# EL PASO COUNTY PLANNING AND COMMUNITY DEVELOPMENT DEPARTMENT

## STORMWATER MANAGEMENT PLAN CHECKLIST

SF-20-014 and EGP-20-004

SHEET 2 OF 5

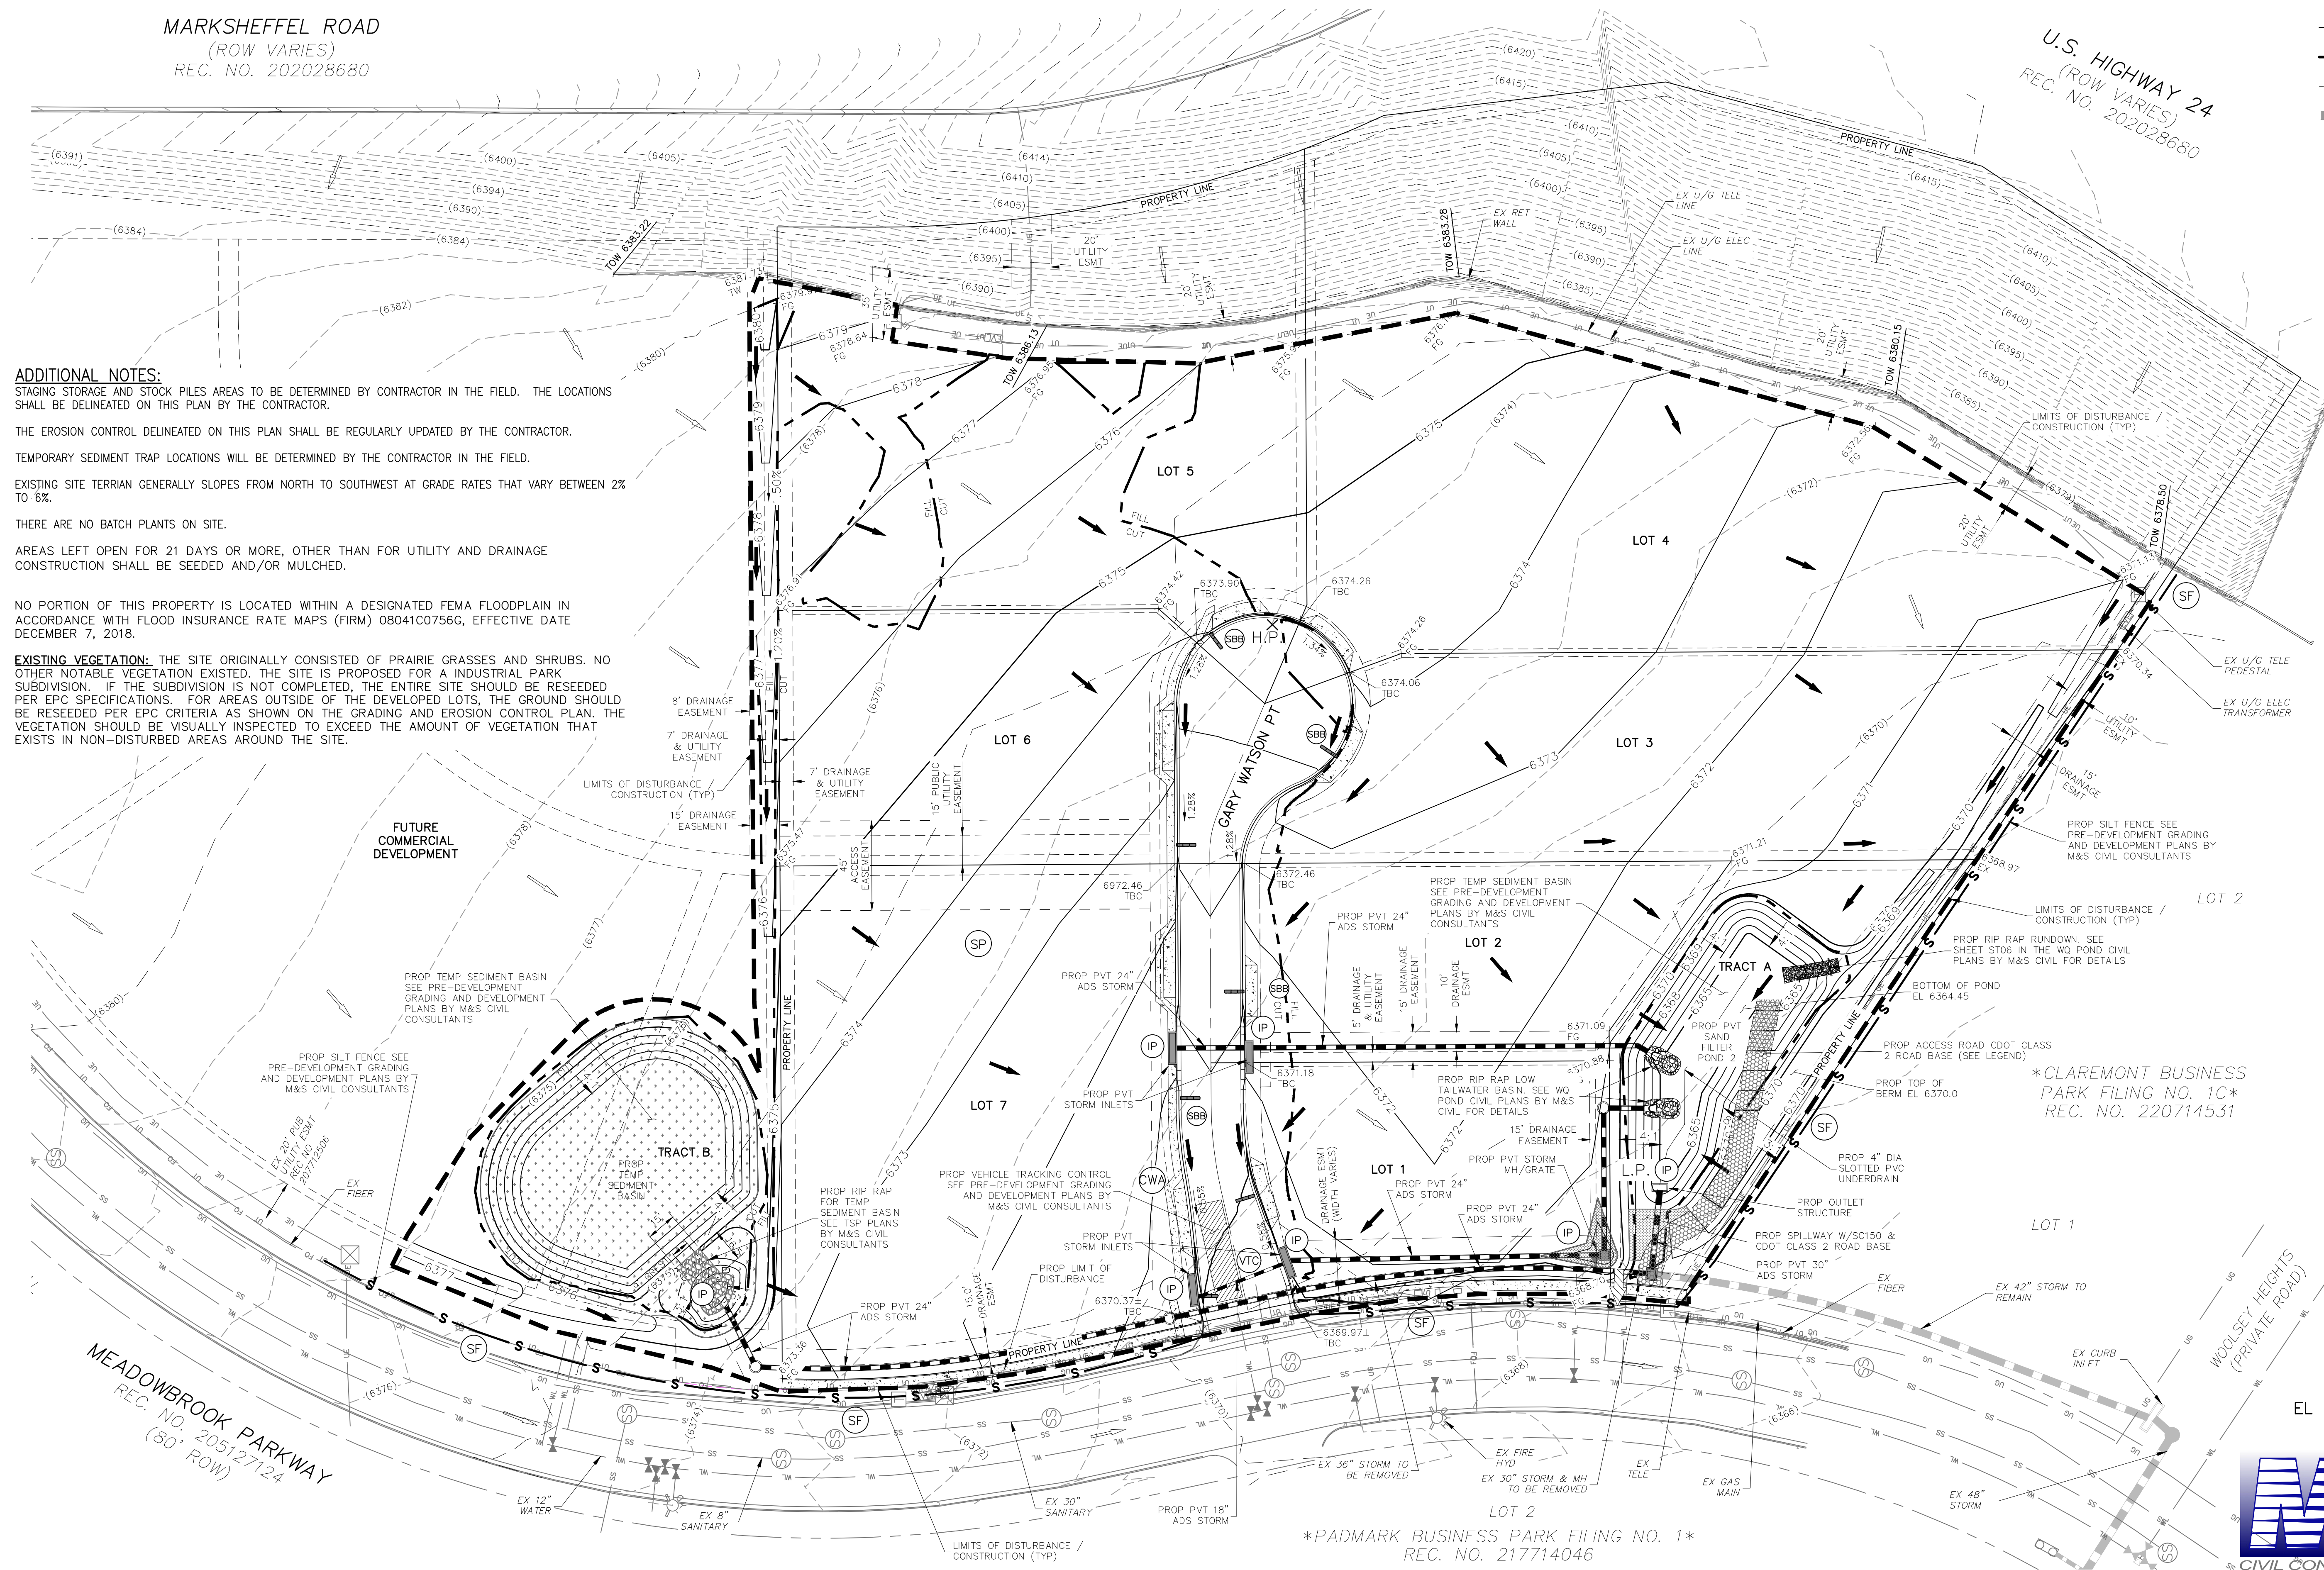
Applicant	PCD
17	SWMP Map to include:		
17a	construction site boundaries	X	X
17b	flow arrows to depict stormwater flow directions	X	✓
17c	all areas of disturbance	X	✓
17d	areas of cut and fill	X	✓
17e	areas used for storage of building materials, soils (stockpiles) or wastes	X	✓
17f	location of any dedicated asphalt / concrete batch plants	N/A	✓
17g	location of all structural control measures	X	✓
17h	location of all non-structural control measures	X	✓
17i	springs, streams, wetlands and other surface waters, including areas that require maintenance of pre-existing vegetation within 50 feet of a receiving water	N/A	✓
18	Narrative description of all structural control measures to be used. Modifications to EPC standard control measures must meet or exceed County-approved details.	X	✓
19	Description of all non-structural control measures to be used including seeding, mulching, protection of existing vegetation, site watering, sod placement, etc.	X	✓
